RE: PR-2020-003887, 2818 4<sup>th</sup> St NW, Site Development Plan for Building Permit

I am writing in response to the review comments dated December 8, 2020 and to request the vacation of the sewer easement.

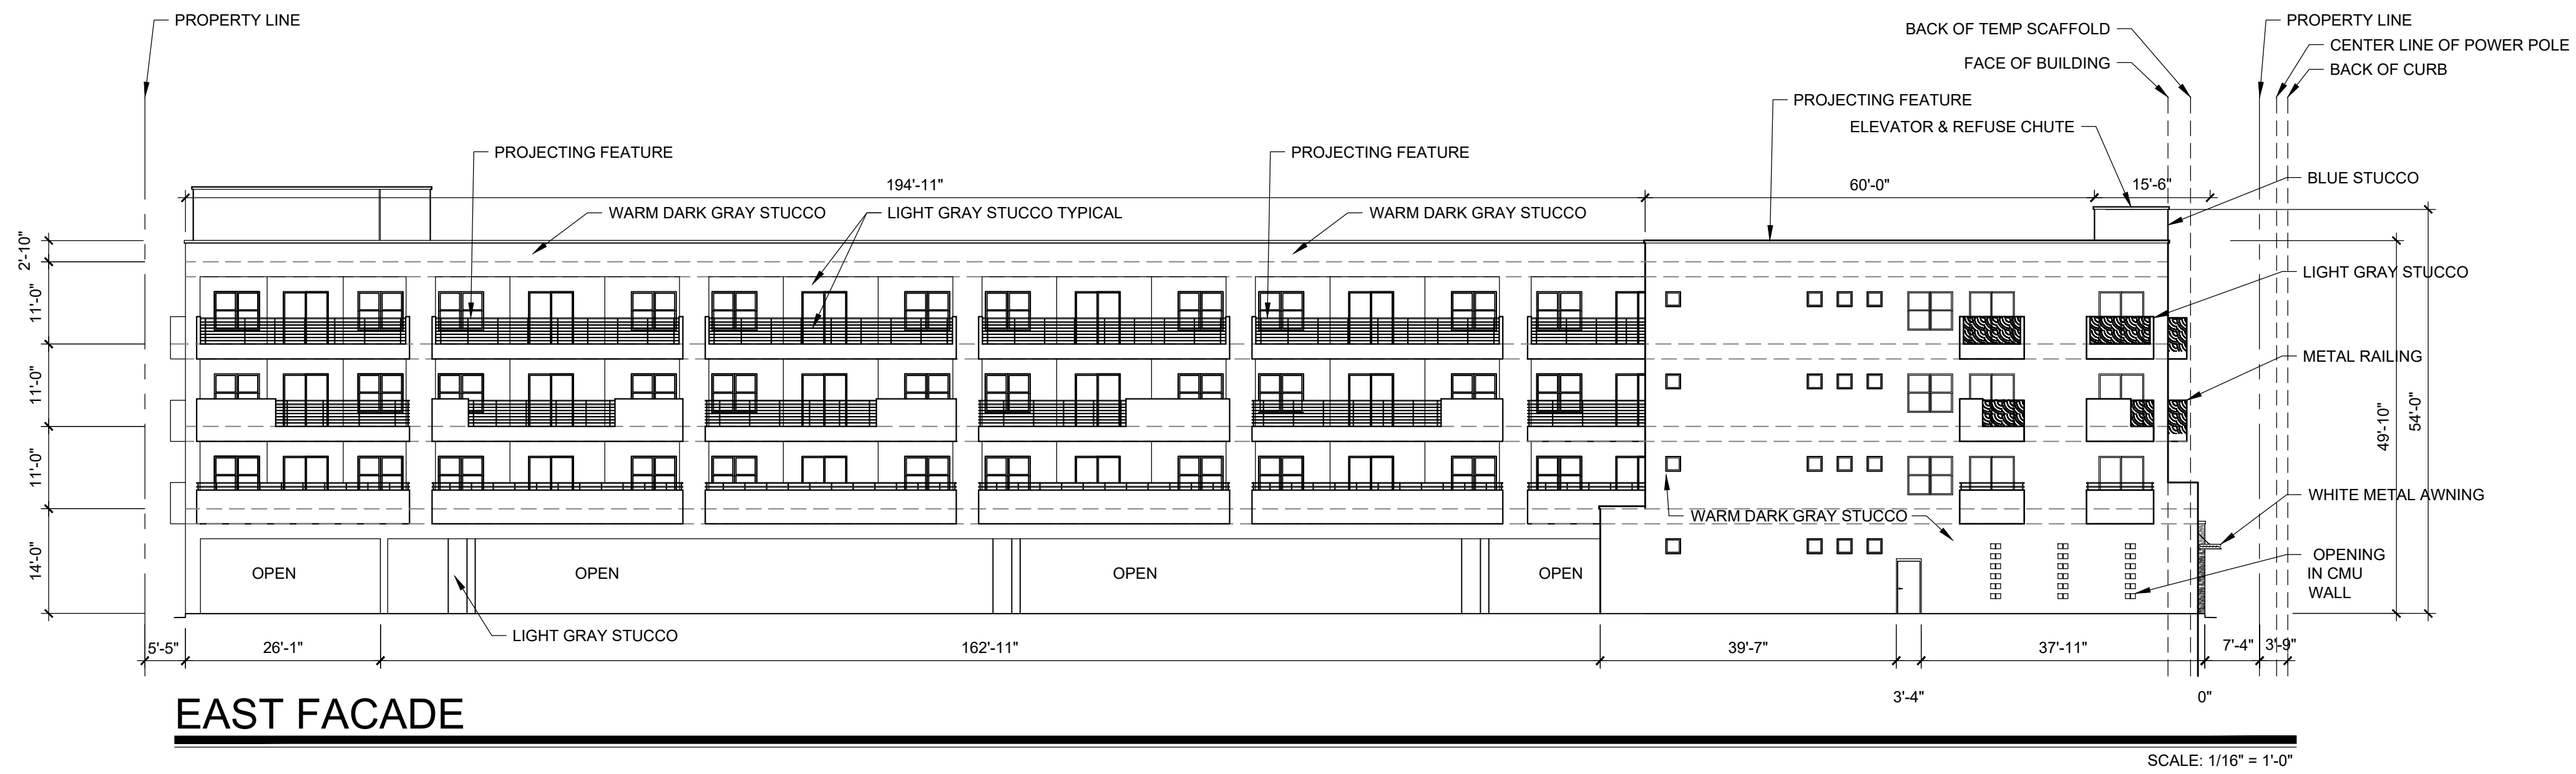
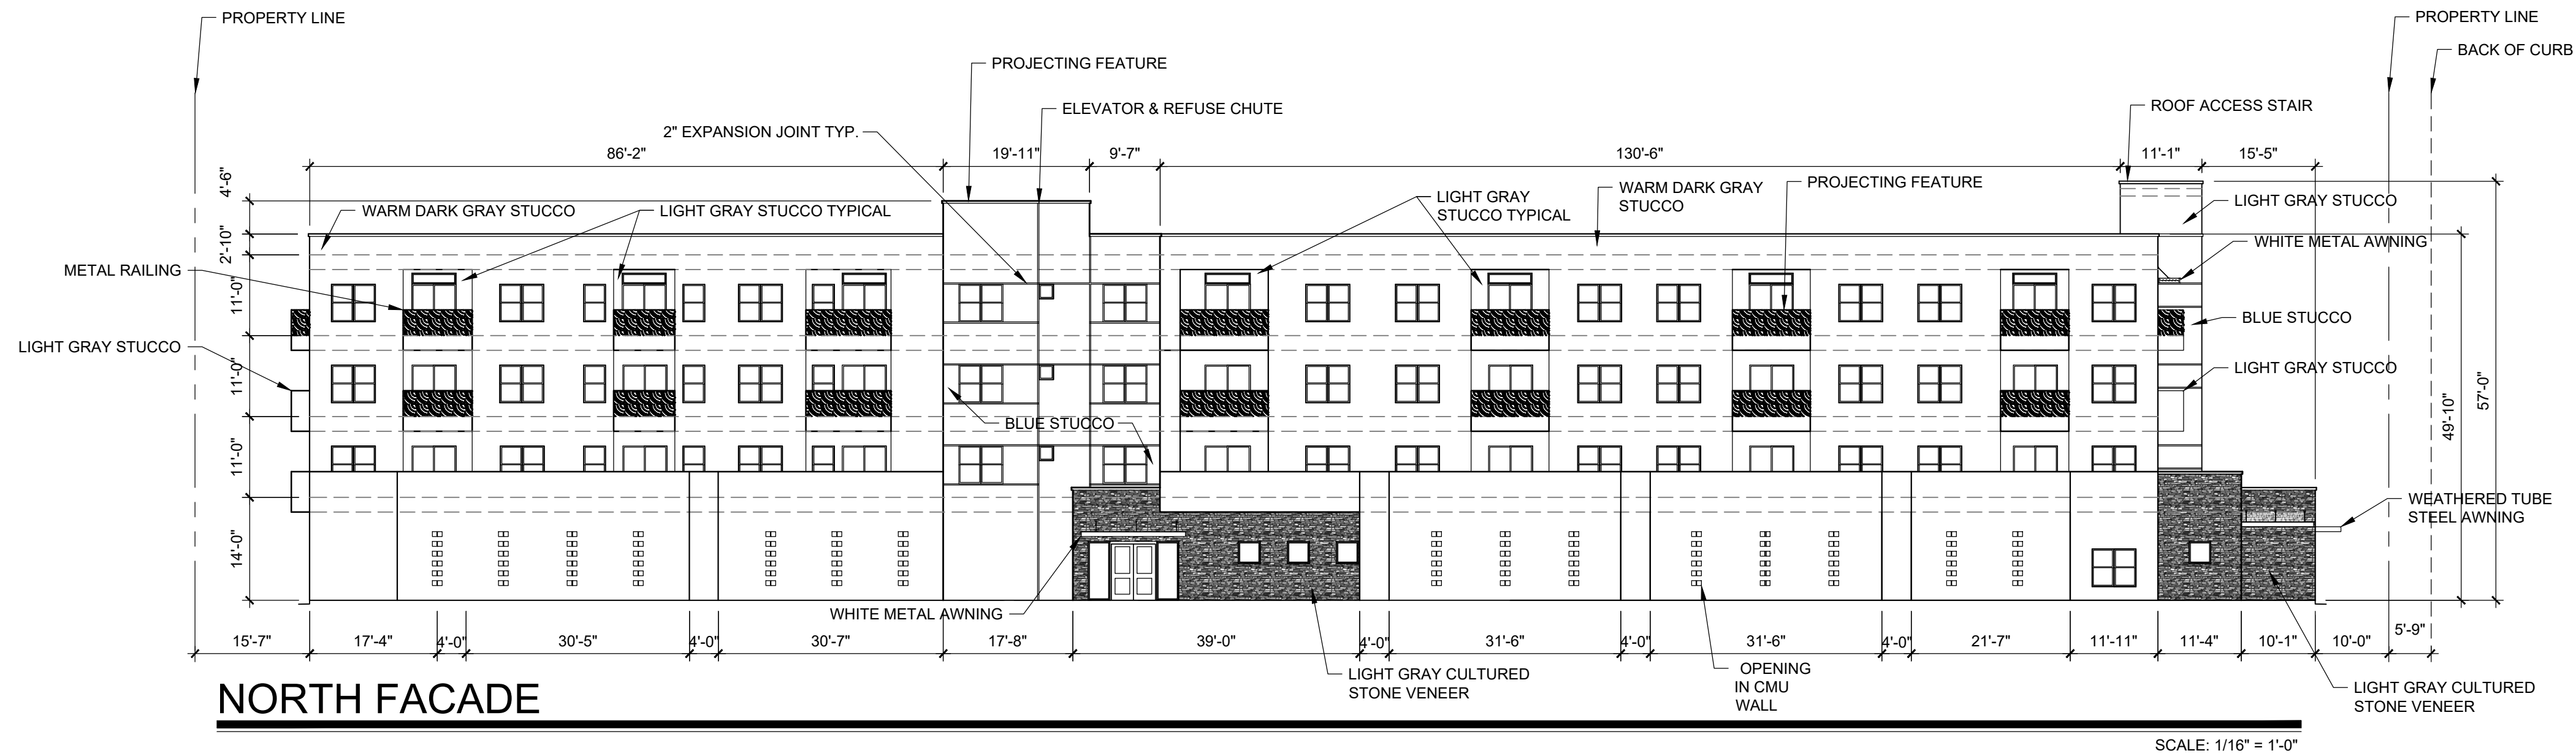
- 1) Sheet A-201 showing 9'3" rear setback – 15 ft setback required variance required.
  - a. The west side of the building faces front and the building has a 4<sup>th</sup> Street address, this makes the east side of the property the back. The North Façade drawing on sheet A-201 shows a setback of 15'-7" from the face of the building. The South Façade on sheet A-202 also shows a 15'7" setback from the west property line.

# RAMP DETAIL

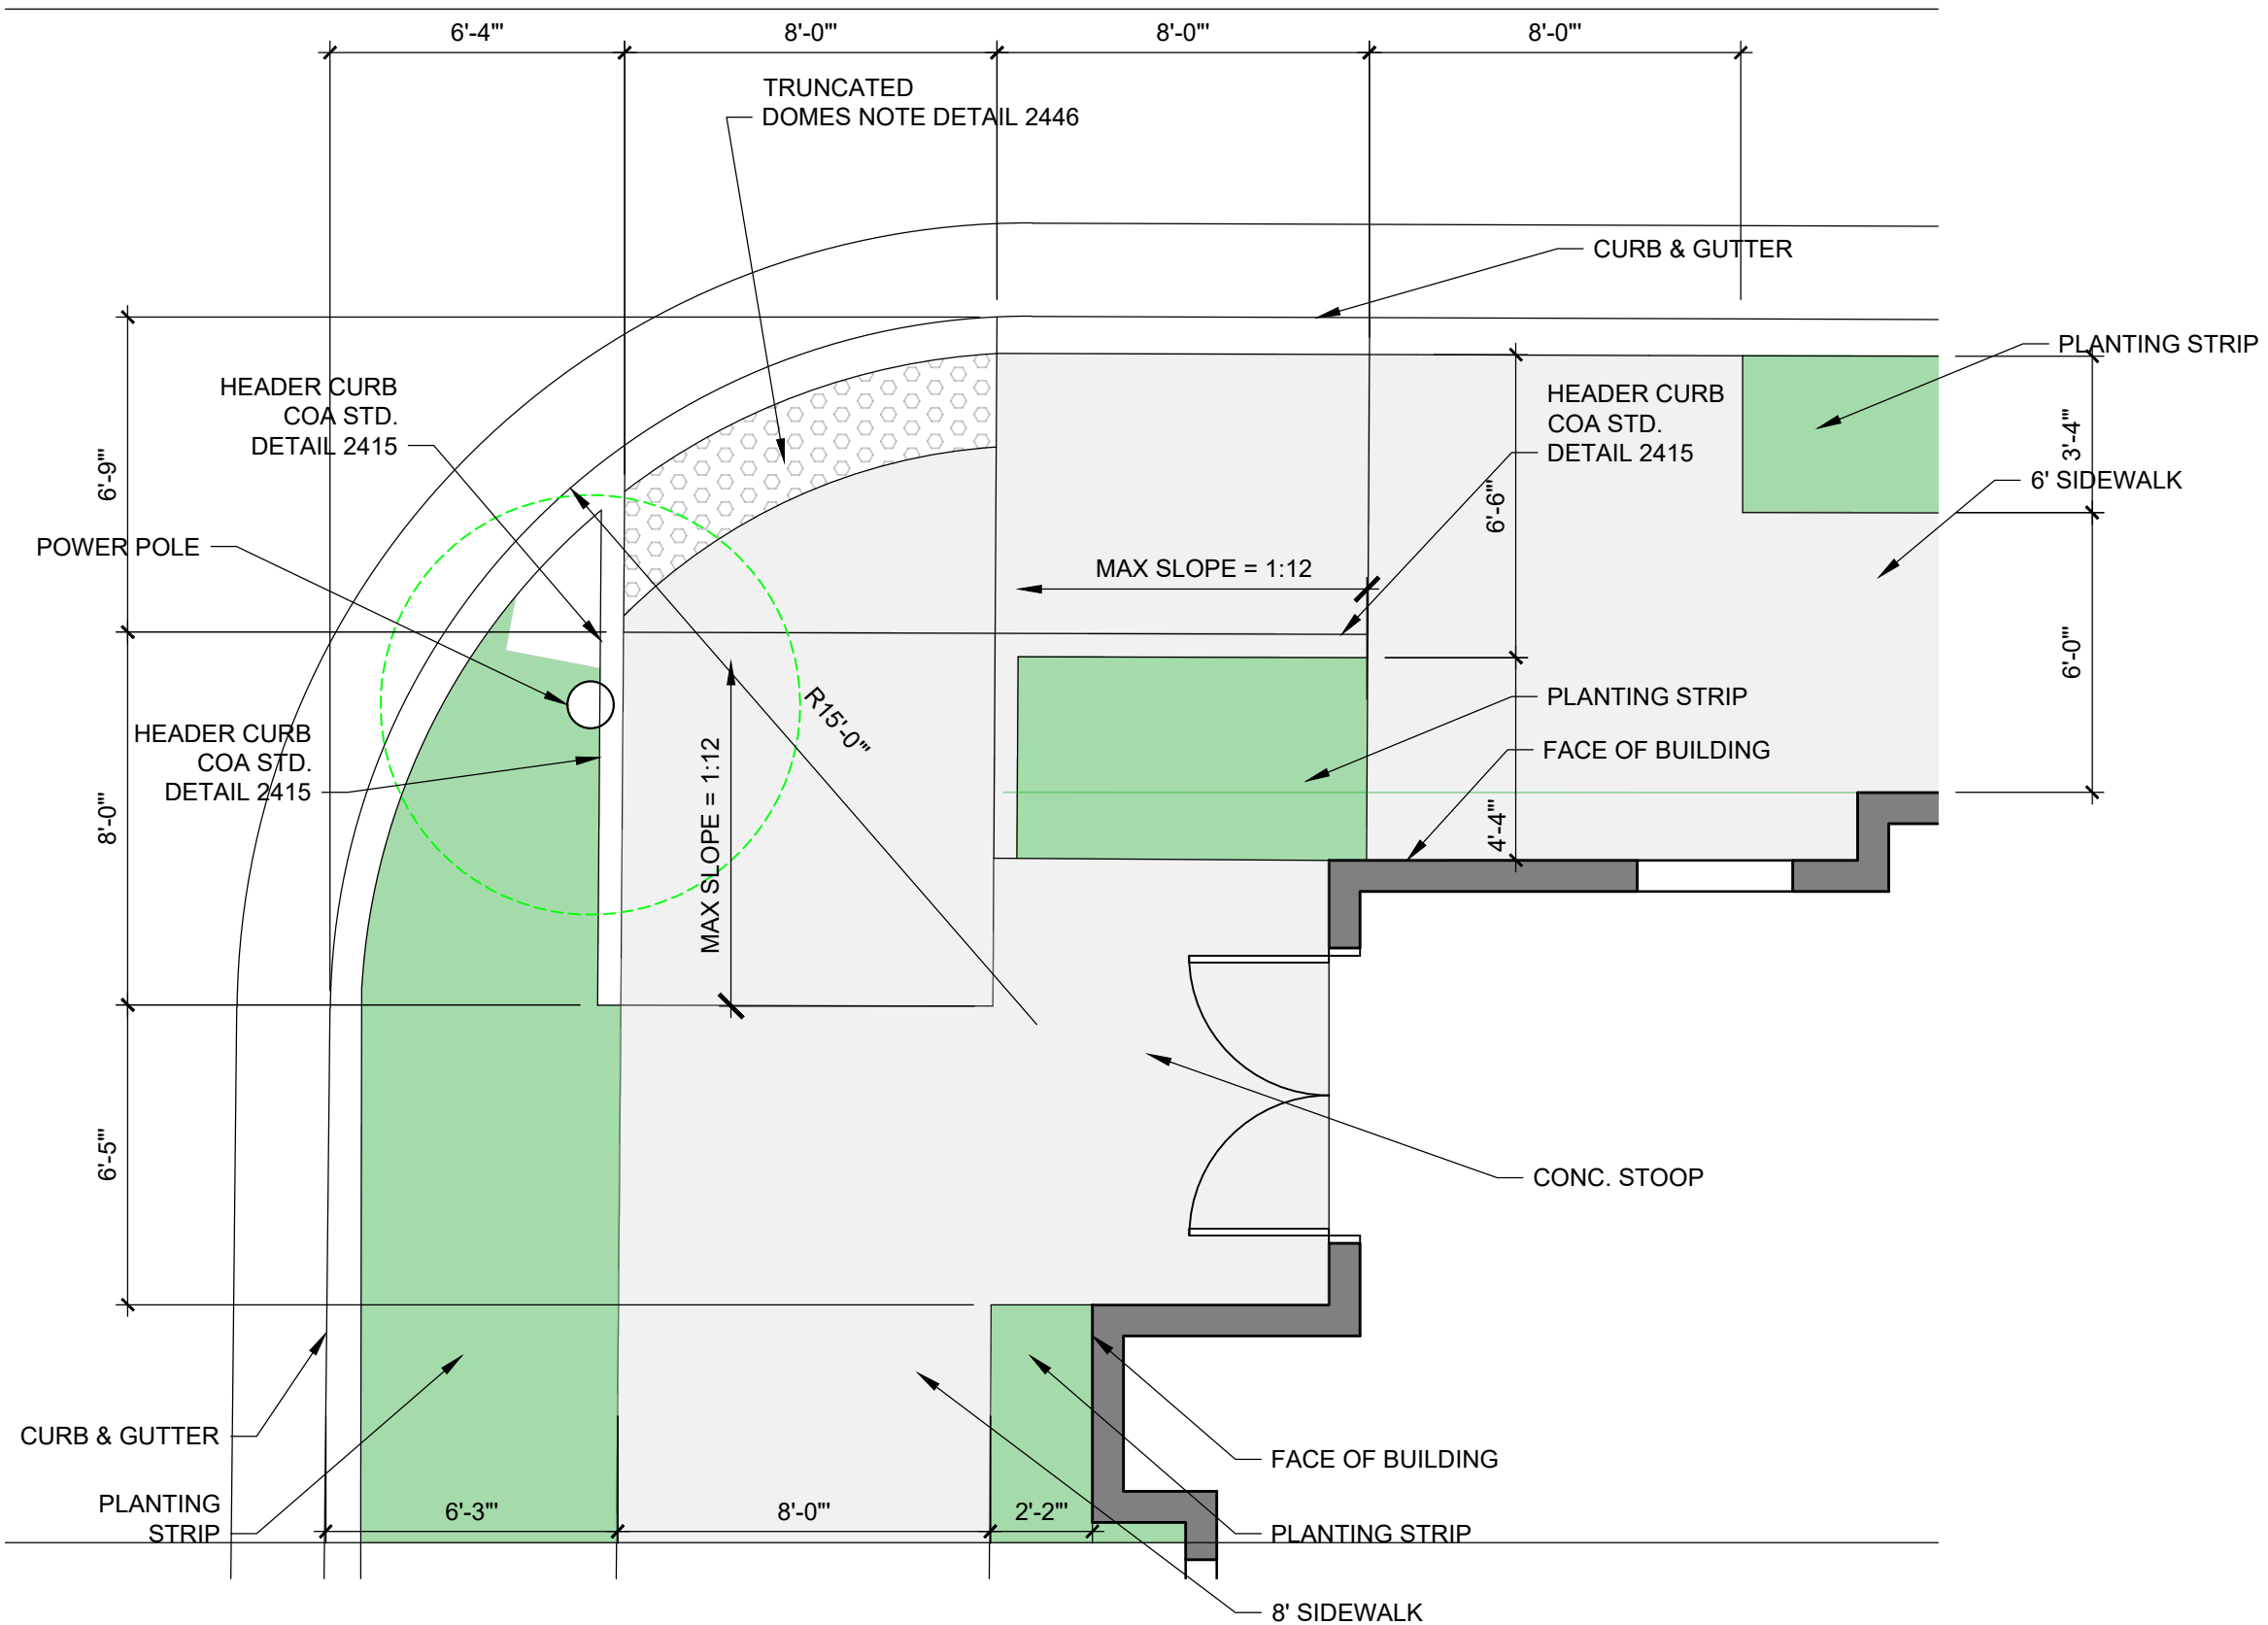
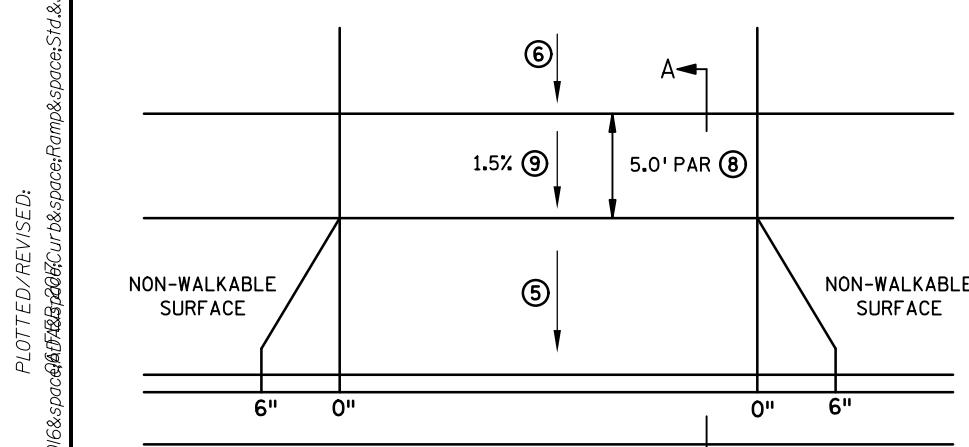
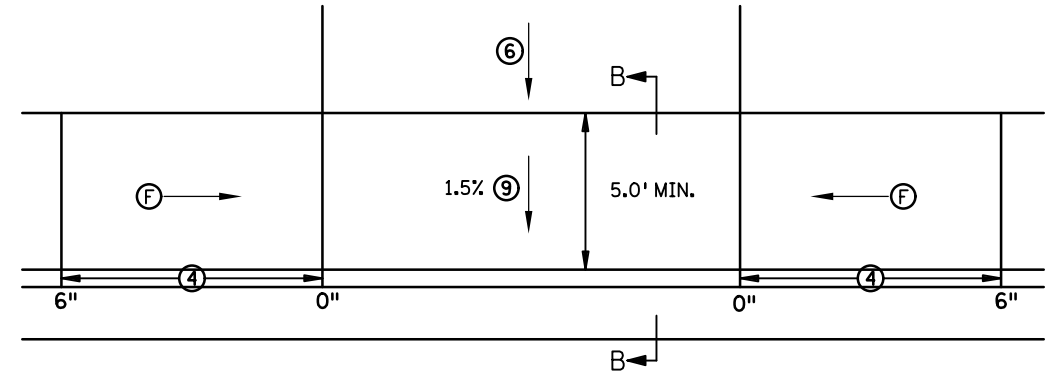
- 1) Show the sanitary sewer easement that is proposed for vacation. Platting approval is required prior to site plan approval.
  - a) Easement added and noted as keyed note "Y" on sheet A-101.
- 2) For driveway details added, show slopes and identify the driveway location on the detail sheet.
  - a) Parallel drive detail used, reference City of Albuquerque standard detail 2426. Keyed note "A" on A-100 revised to reflect this change. Drive entrances revised to coordinate with this detail.
